Your Ref: 2023/93597

Our Ref: A000519

2nd December 2024

east of, Mill Lane, and Heaton Grange, Hanging Heaton, Batley, WF17 6EN – Reserved matters application pursuant to outline permission 2020/93777 for erection of residential development (19 dwellings)

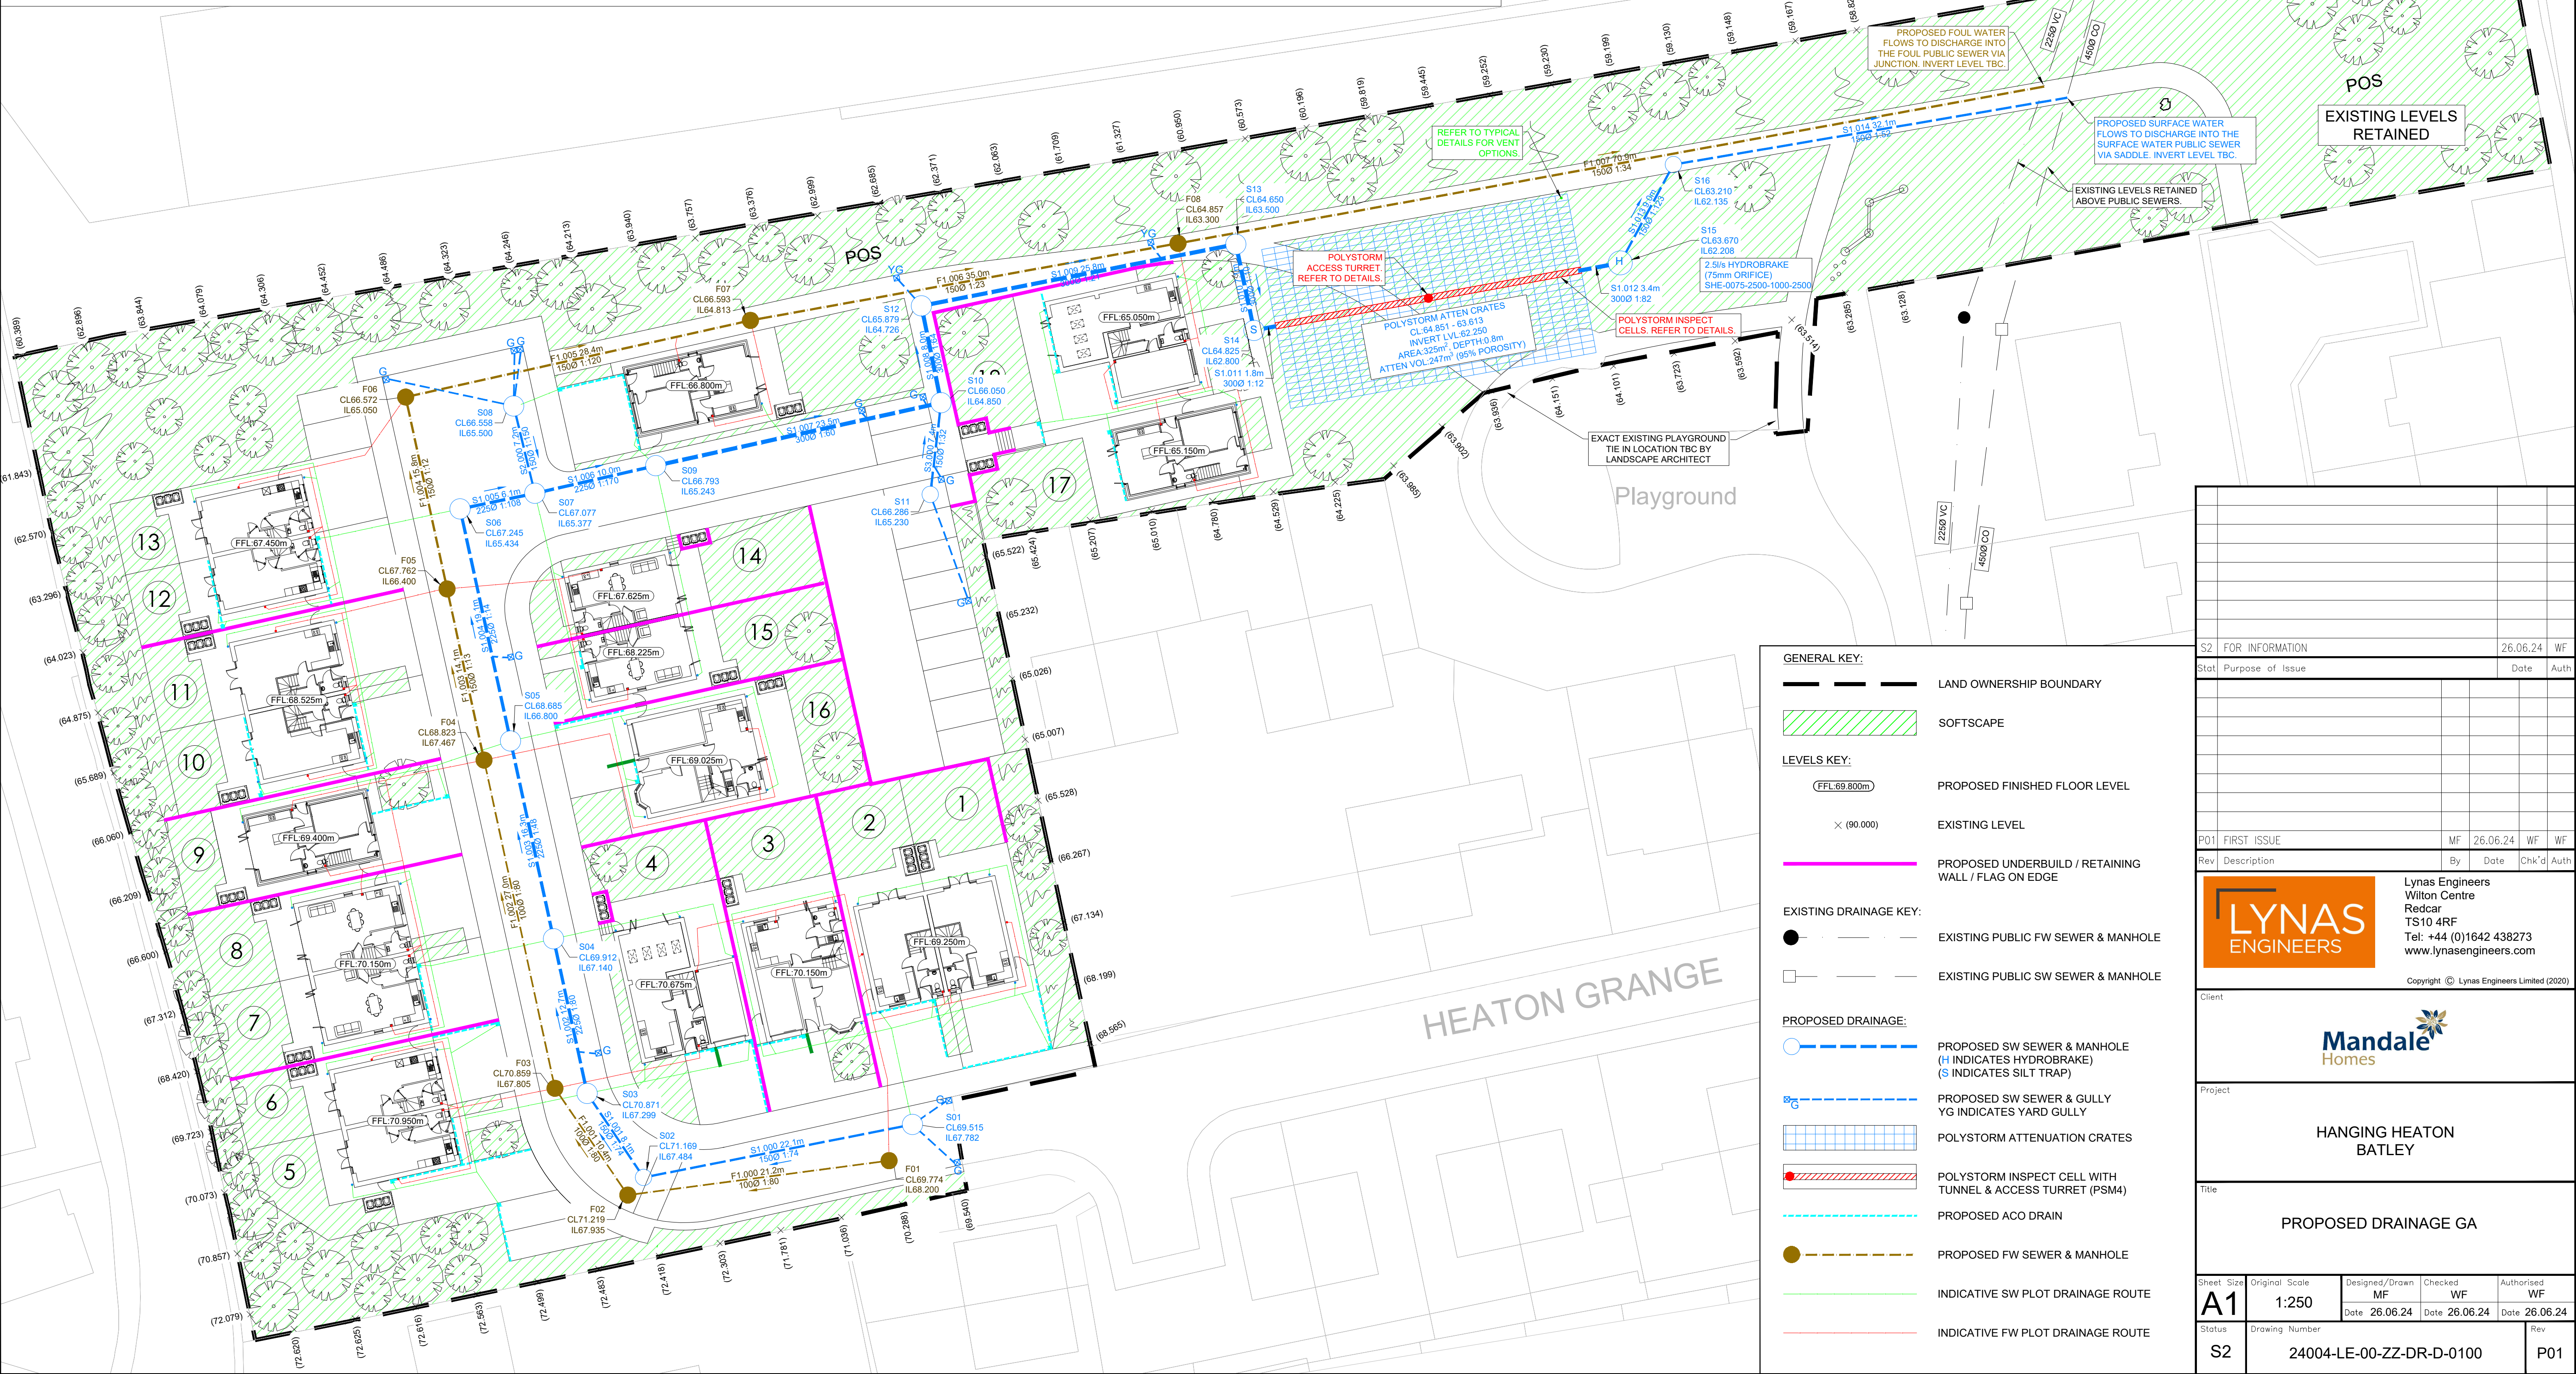
1) The drainage details submitted on drawing 24004-LE-00-ZZ-DR-D-0100 (revision P01) dated 26/06/2024 that has been prepared by Lynas Engineers require amendments. The following point should be addressed:

a) Evidence should be submitted to show that other (than discharge to public sewer) means of surface water disposal have been considered and why they have been discounted

2) The developer is proposing to discharge surface water to public sewer however, sustainable development requires appropriate surface water disposal.

a) Yorkshire Water promote the surface water disposal hierarchy and the developer must provide evidence to demonstrate that surface water disposal via infiltration or watercourse are not reasonably practical before considering disposal to public sewer.

b) The developer and LPA are strongly advised to seek comments on surface water disposal from other drainage bodies as further restrictions may be imposed.

c) As a last resort, The surface water discharge from the proposal to the public surface water sewer network must be restricted so as not to exceed 2.5 (two point five) litres per second.
